Department of
Infrastructure, Planning and Natural Resources

Planning Assessment Report

Development Application DA 492-11-2003

The application seeks consent for the erection of a four (4) storey building with four (4) tourist units, ground floor retail space, parking, gymnasium and cinema.

DRAWING TITLES
ELEVATIONS

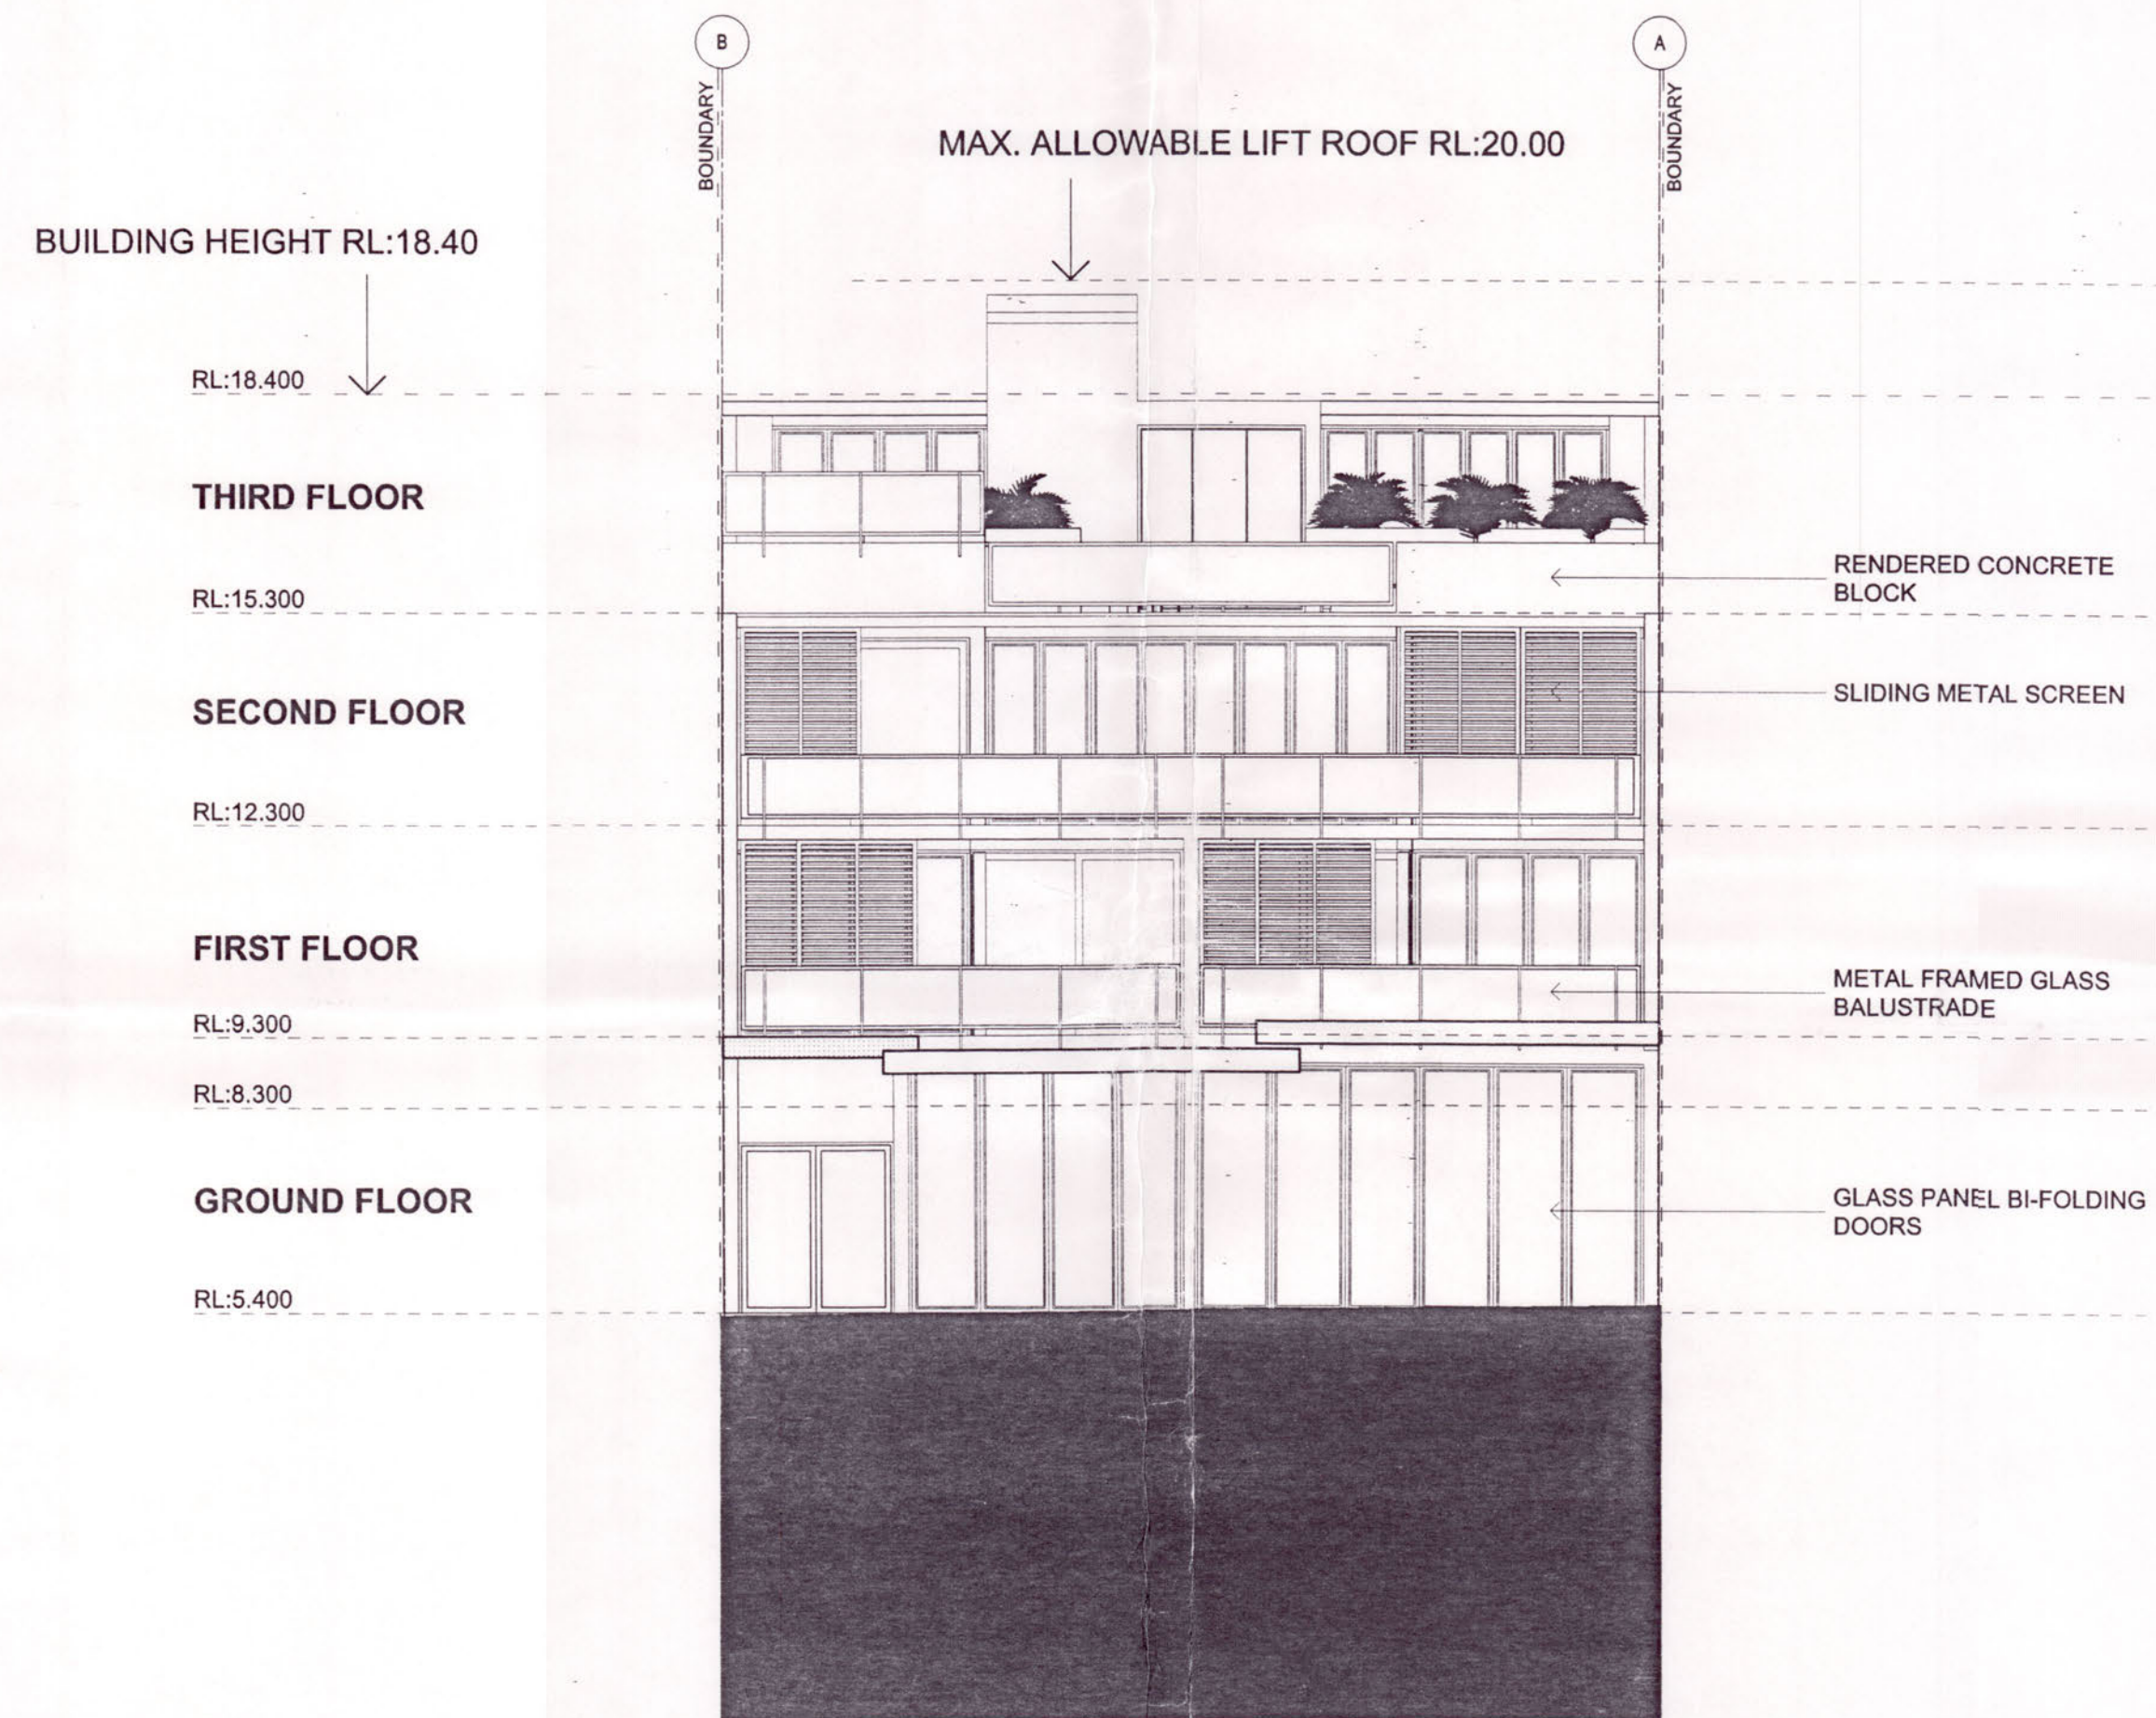
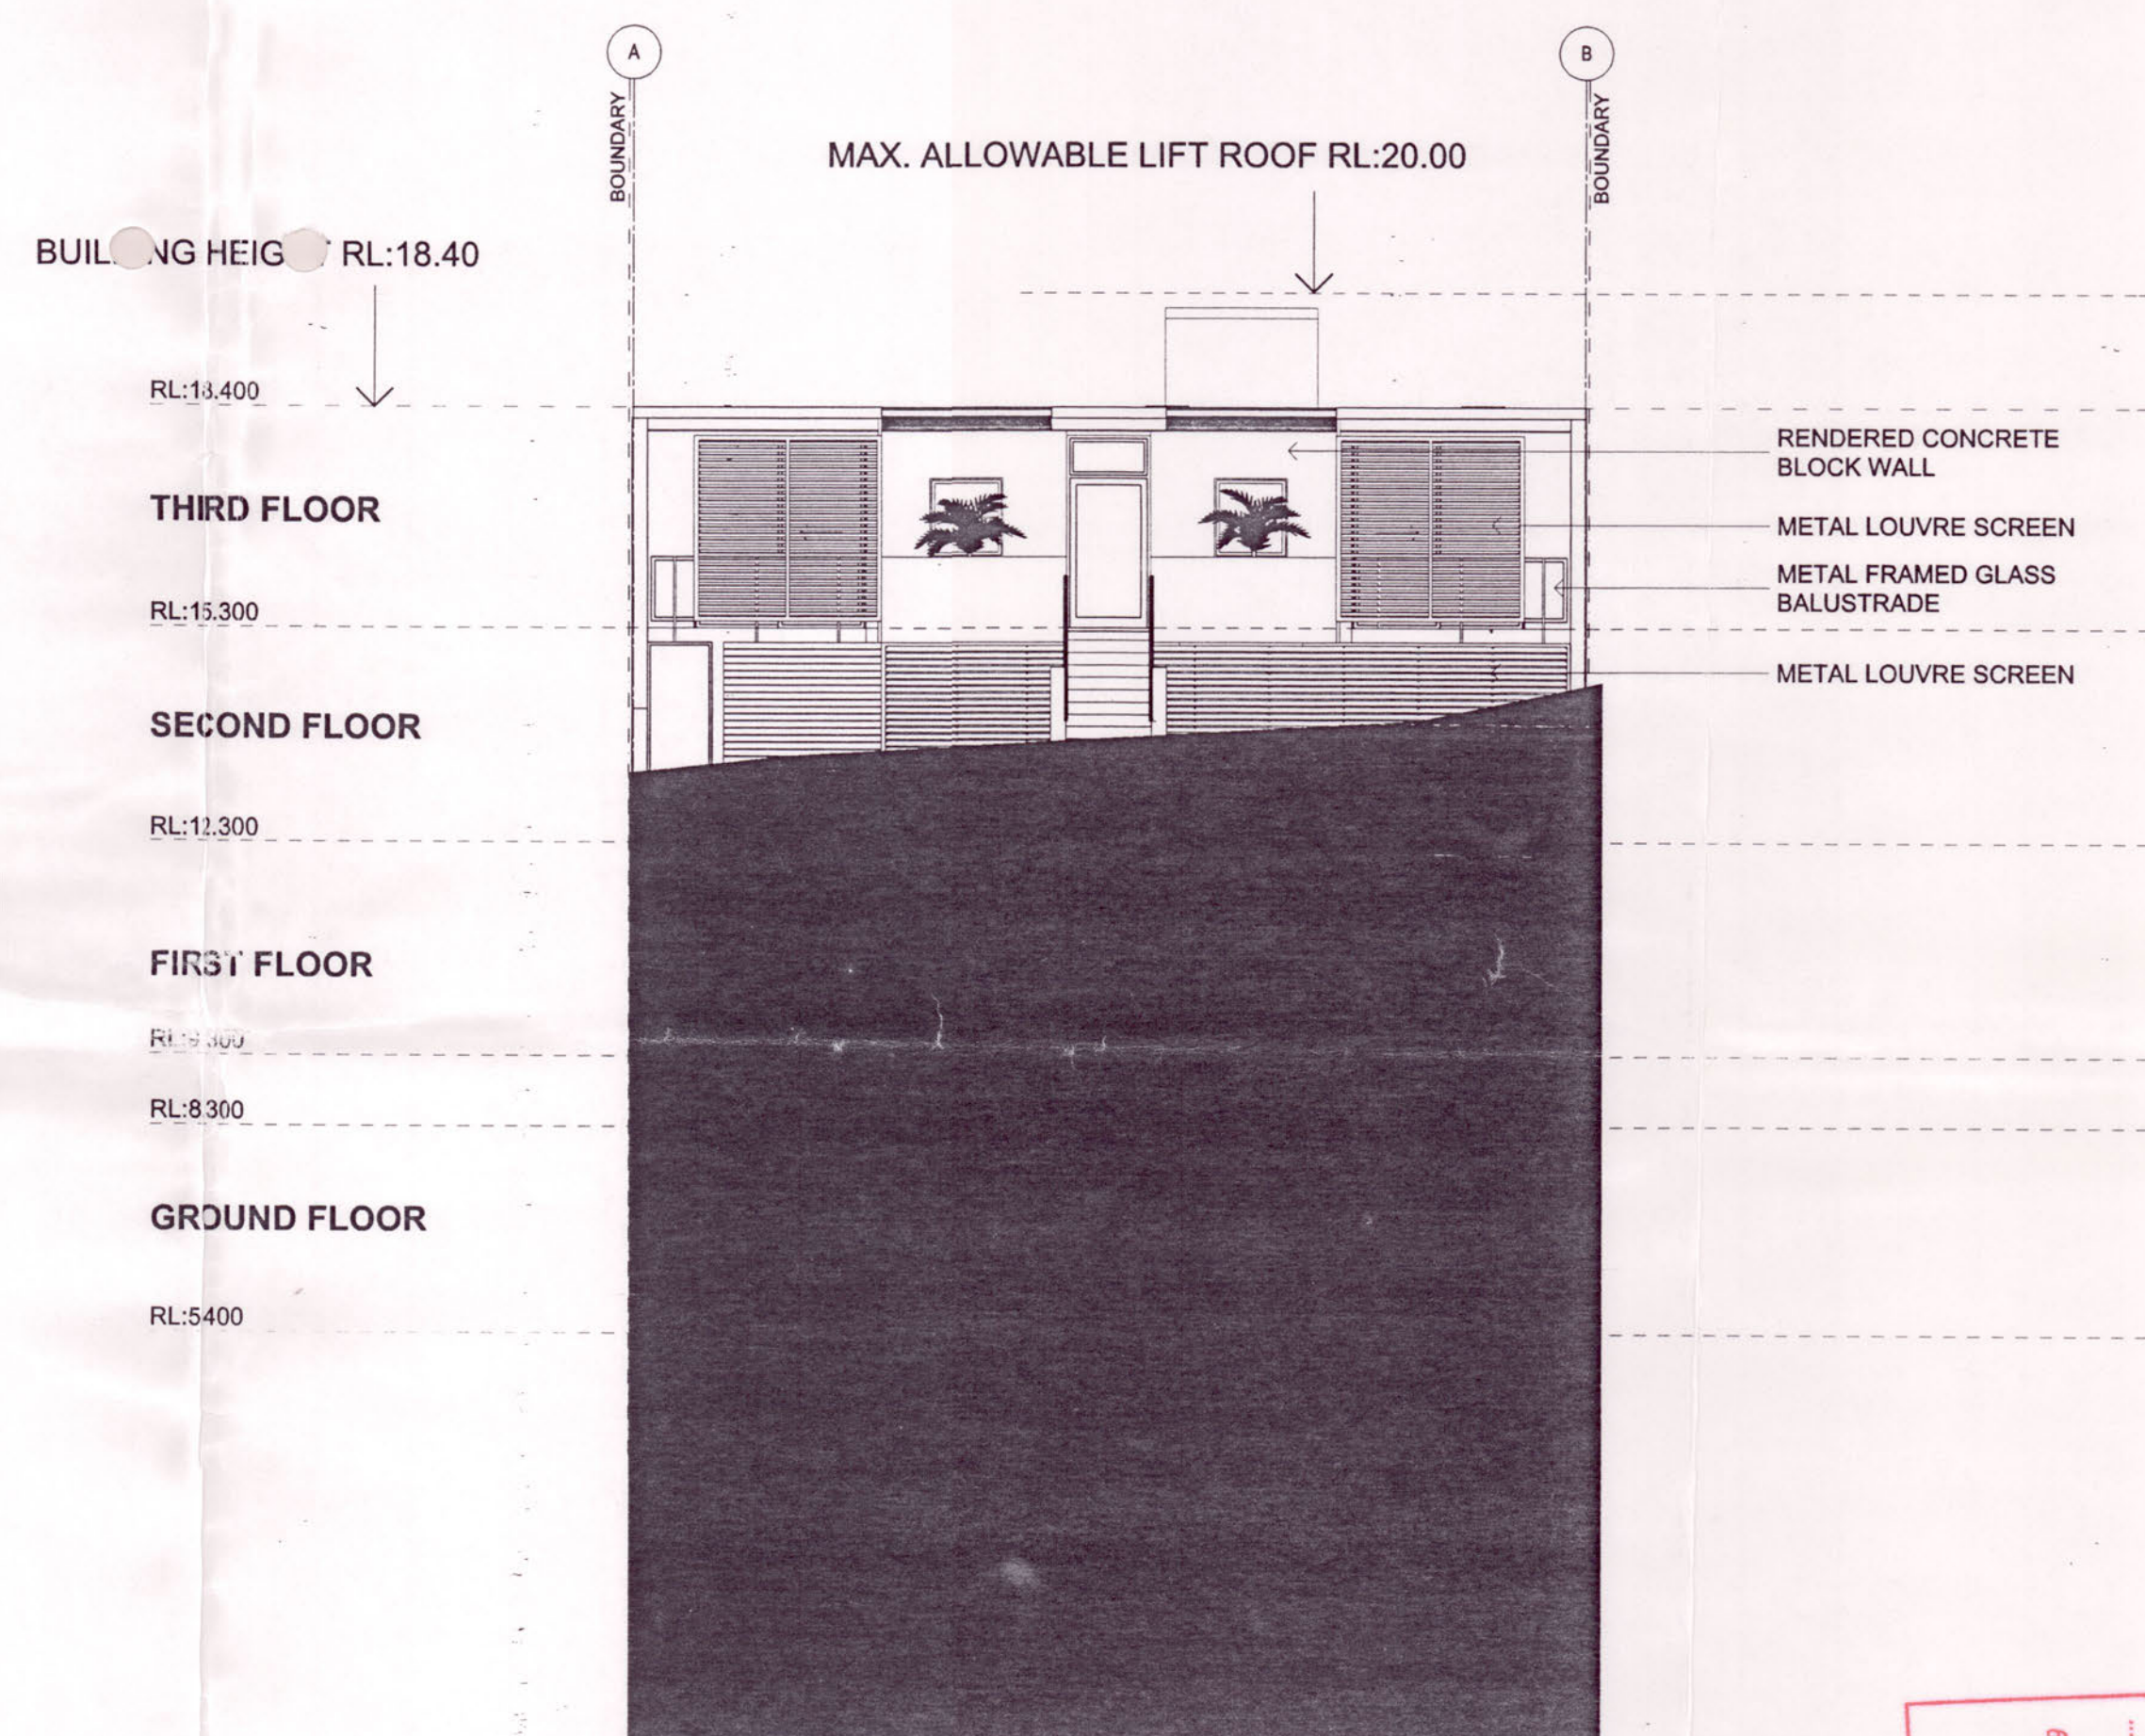
Issue: The proposed development exceeds height limit as defined by Tweed Local Environmental Plan 2000 (TLEP 2000) and Clause 51 of North Coast REP.
Raised by: DIPNR – Urban Assessment, Council, Local community
Consideration: The land has a three storey height limit under TLEP 2000 above natural ground level. Due to the development's non-compliance with the current definition of height, an objection under State Environmental Planning Policy No. 1 – Development Standards (SEPP 1) has been lodged by the applicant.
Resolution: It is considered that the impact of the development's height in terms of visual impact will be minimal from Marine Parade as the fourth storey is setback 17m from the front and consists of the lift area and lobby. This structure will not be visible from the street or the foreshore. However it will be visible from the foreshore park. The development however, is consistent in height with the adjoining property.

The appropriate concurrences have been granted subject to conditions
